From: Stephen milliner [REDACTED]
Sent: 11 April 2019 15:43
To: Juan Baeza; Planning.Responses
Subject: EP/43/19/DOC 60 Vermont Drive, East Preston

LOCATION OF PROPOSED
BIKE SHED

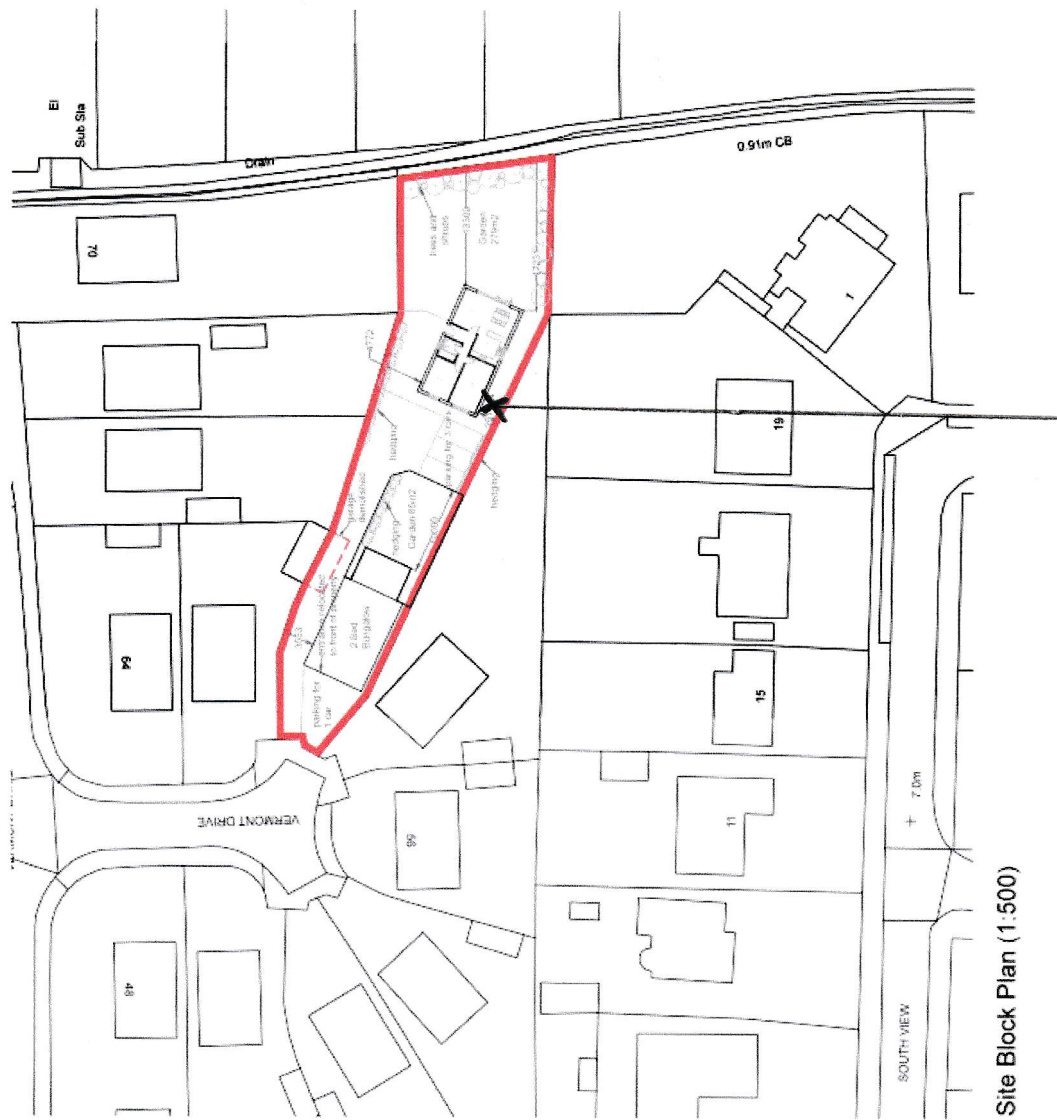
Are the Council satisfied there is sufficient information to validate the application? The plan simply shows a "X marks the spot" and does not show the accurate location or orientation of the proposed cycle store.

Condition 8 requires the provision of covered and secure cycle spaces. The provision identified by the applicant looks to be a single cycle lock up when compared to typical manufacturers dimensions/definitions. The planning condition requires provision for multiple cycles as the plural term is used. I assume you will see that multiple covered and secure spaces as necessary for the development will be provided.

Are you satisfied this is a proper cycle store rather than a lock up facility and is it secure as normally defined/deemed necessary by the Council?

The cycle lock up looks rather industrial/commercial in my opinion and more akin to the type of cycle locker you might see on an industrial/commercial estate rather than commensurate with the visual amenity of a residential development.

Are the Council satisfied that a minimum clear 1500 mm will be available in front of the proposed cycle store to allow correct use?
